From: Christian Melgar [REDACTED]
Sent: 22 October 2024 12:15
To: Planning.Responses <Planning.Responses@arun.gov.uk>
Subject: RE: Planning Consultation on: BR/180/24/PL

Please find response to Planning application BR/180/24/PL from Arun District Council Private Sector Housing and Public Health.

Application No: BR/180/24/PL

Description of Works: Change of use from 8 bedroom House in Multiple Occupation (HMO) to 11 bedroom HMO. This application is in CIL zone 4 and is CIL liable.

Drg. No. PG.9011 · 24 · 02 Rev. B

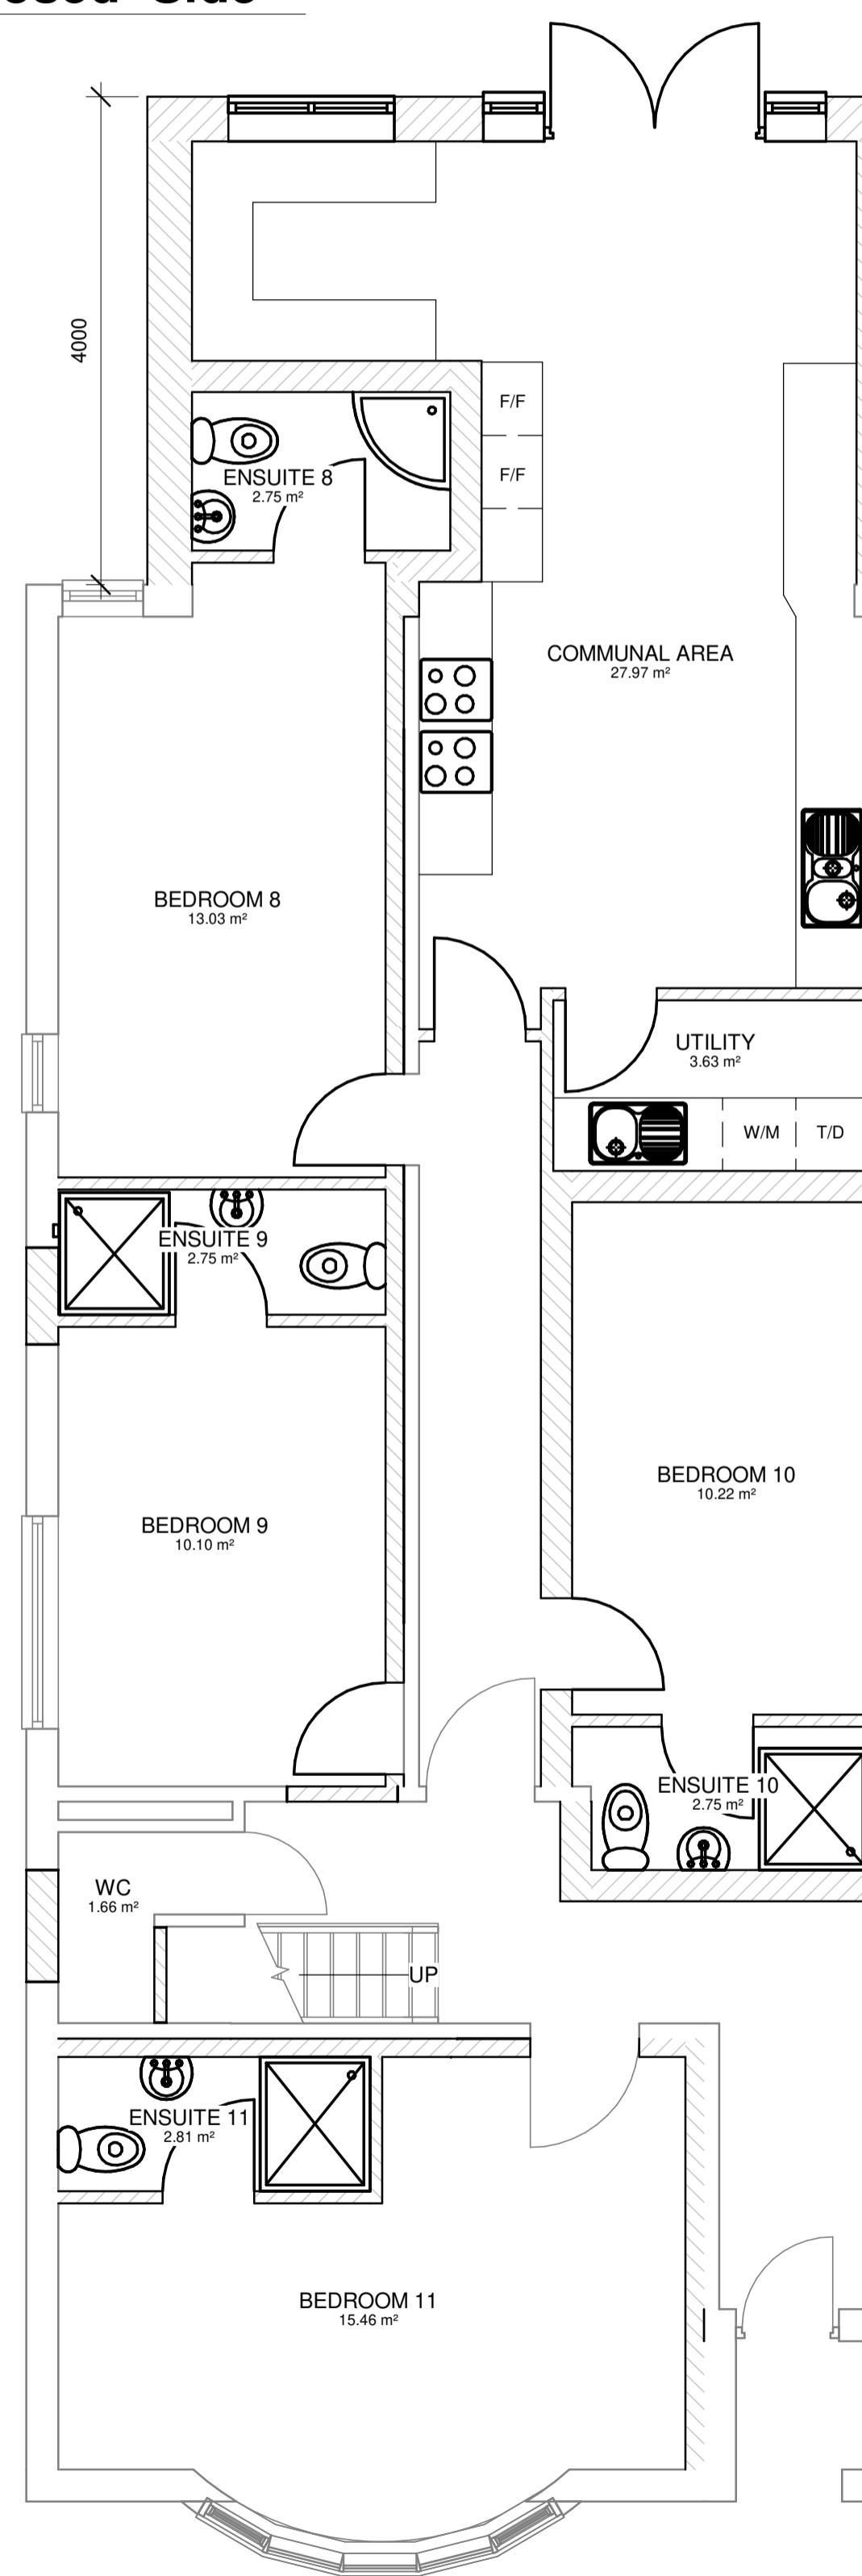
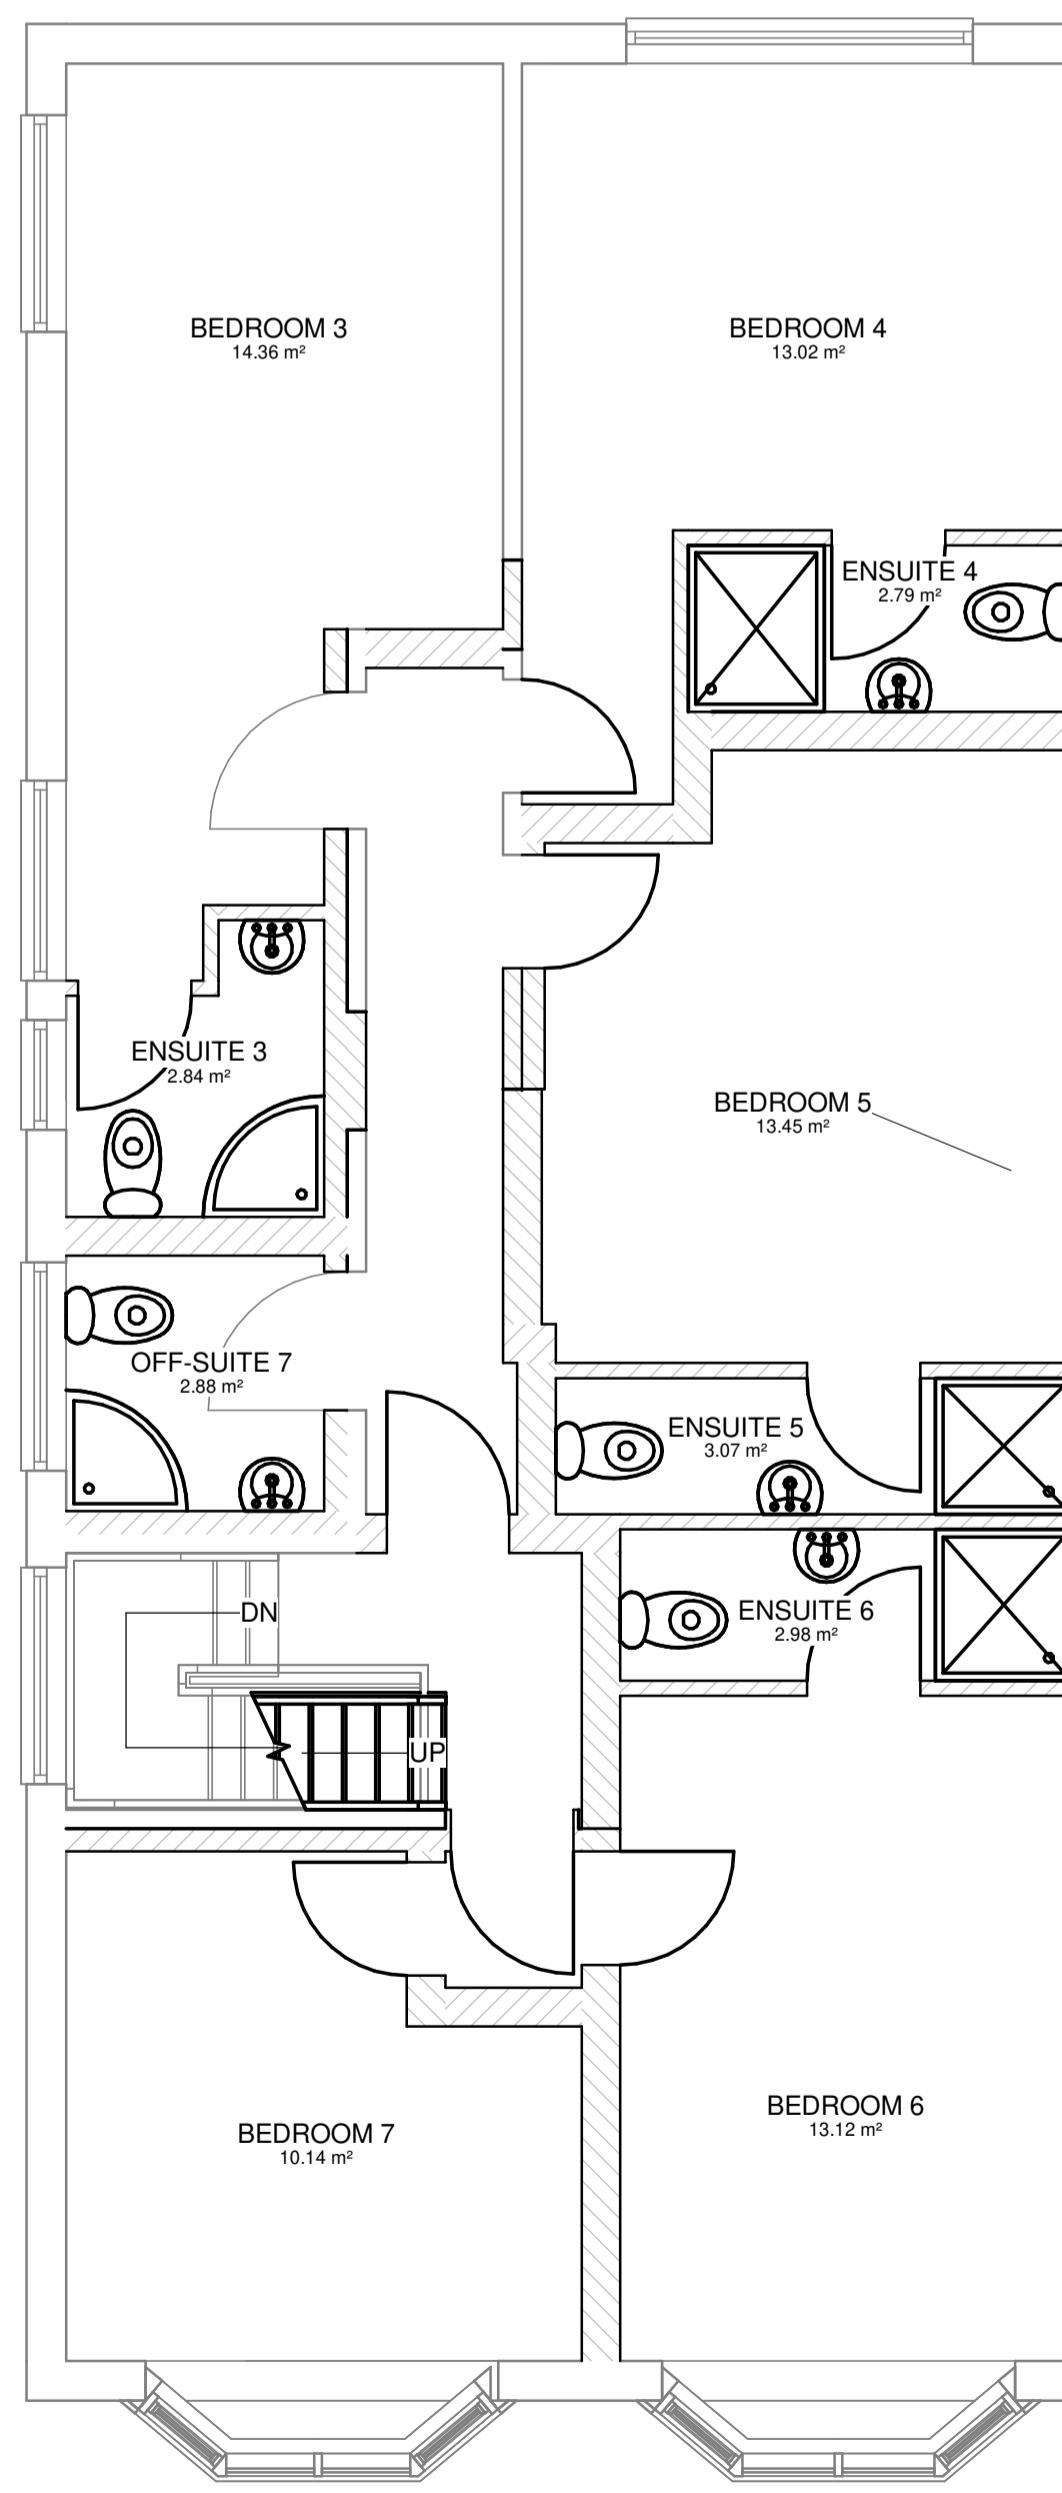
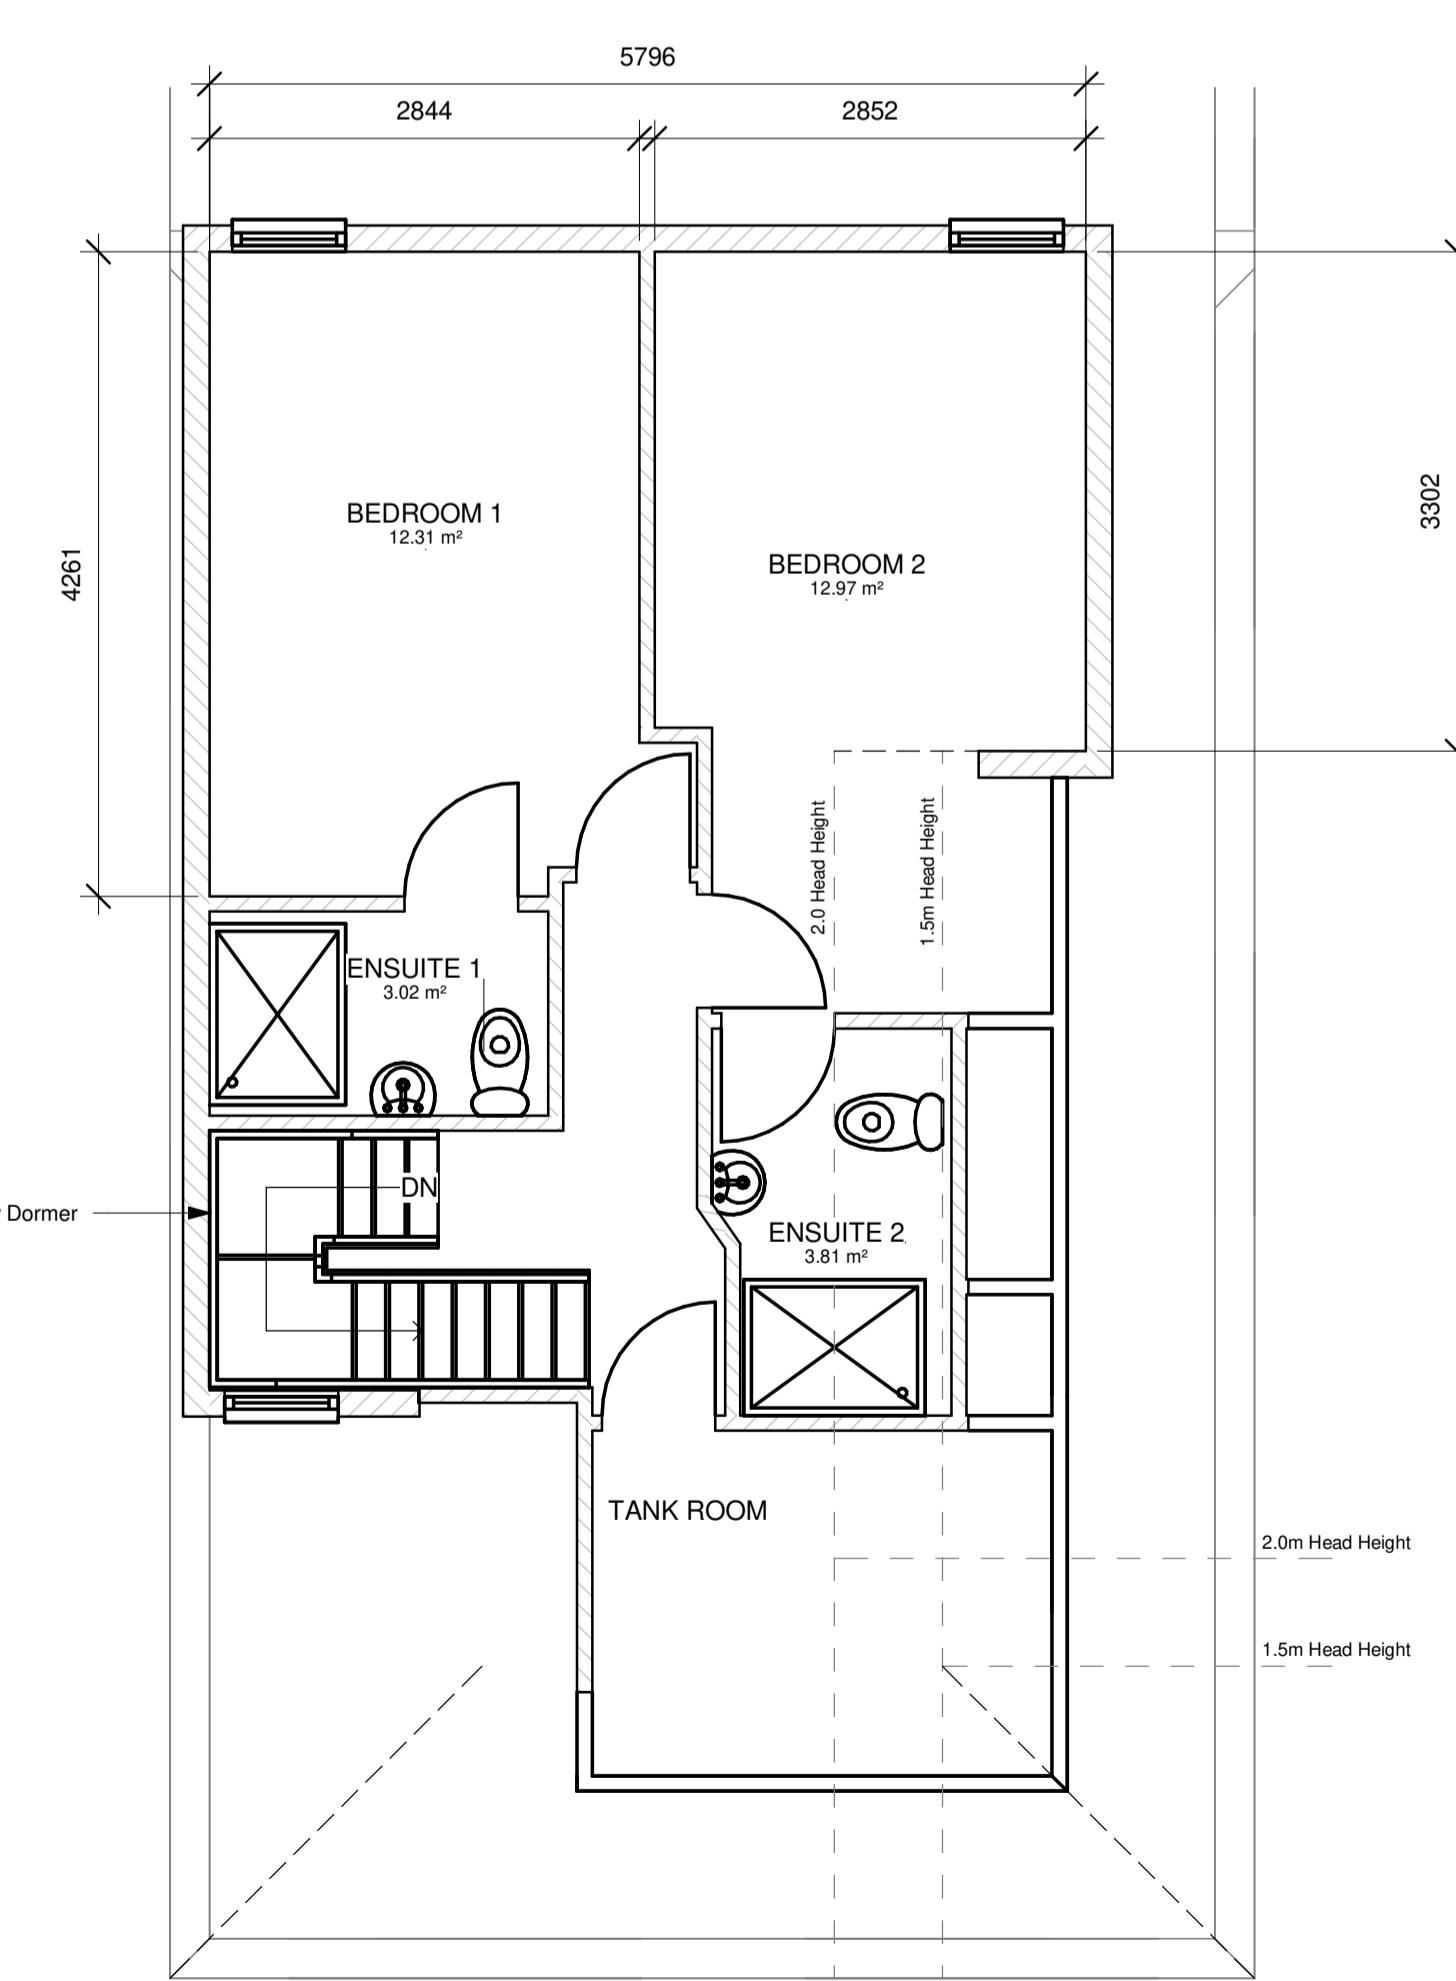
- Some of the proposed ensuite bathrooms do not appear to be of an adequate size or layout, with minimal drying and changing space and with inward opening doors that appear to require the user to squeeze into tight spaces to be able to open the door. Bathrooms must be of an appropriate size to provide adequate changing and drying space for the user. From the proposed plans, the ensuite bathrooms appear very narrow and compact, increasing the likelihood that users will collide with the walls and/or fixtures around them. Although there is no minimum size for a bathroom, generally bathrooms measuring less than 2m² are more likely to contain hazards which pose a risk to the users (it is noted that the measurements on the proposed plans are >2m²). However, the layout of bathrooms is equally important, as poorly located amenities can also create a risk to users. For example, if your elbows are touching the walls either side when standing in the bathroom, it is possible the case officer will determine it is not adequate and improvement work will be required in accordance with The Licensing and Management of Houses in Multiple Occupation and Other Houses (Miscellaneous Provisions) (England) Regulations 2006. This could also be identified as a hazard under the Housing Health and Safety Rating System (HHSRS), therefore consideration should be given to reconfiguring (some of) the ensuite bathrooms.

- Although not shown in any detail on the submitted plan, the WC on the ground floor, must have a wash hand basin provided and that has a constant supply of hot and cold water. If the compartment only has a WC in it, a cloakroom basin is adequate.

- The head height of the en-suite bathroom for Bedroom 2 above the toilet is between 1.5m and 2m in height and could potentially pose a collision hazard, whereby a user could hit their head on the ceiling.

- There should be appropriate provision of dining facilities for the number of occupants.
- On the submitted plans, the two hobs indicated are very close together. If they are located too close, it may not be possible to fully utilise all rings at once as doing so could result in having to reach over other hot rings. The two hobs should be suitably spaced to allow for use of all rings at once but without having to reach directly over other rings.

- Kitchens and bathrooms/shower rooms/ensuites must have adequate mechanical extraction, regardless of any windows present.
- The windows to bedrooms 1,2 and 8 appear small and should be equivalent to 1/20th of the floor area. Windows should provide a reasonable view as well as adequate ventilation, to this end, some Velux-type windows will not be appropriate.
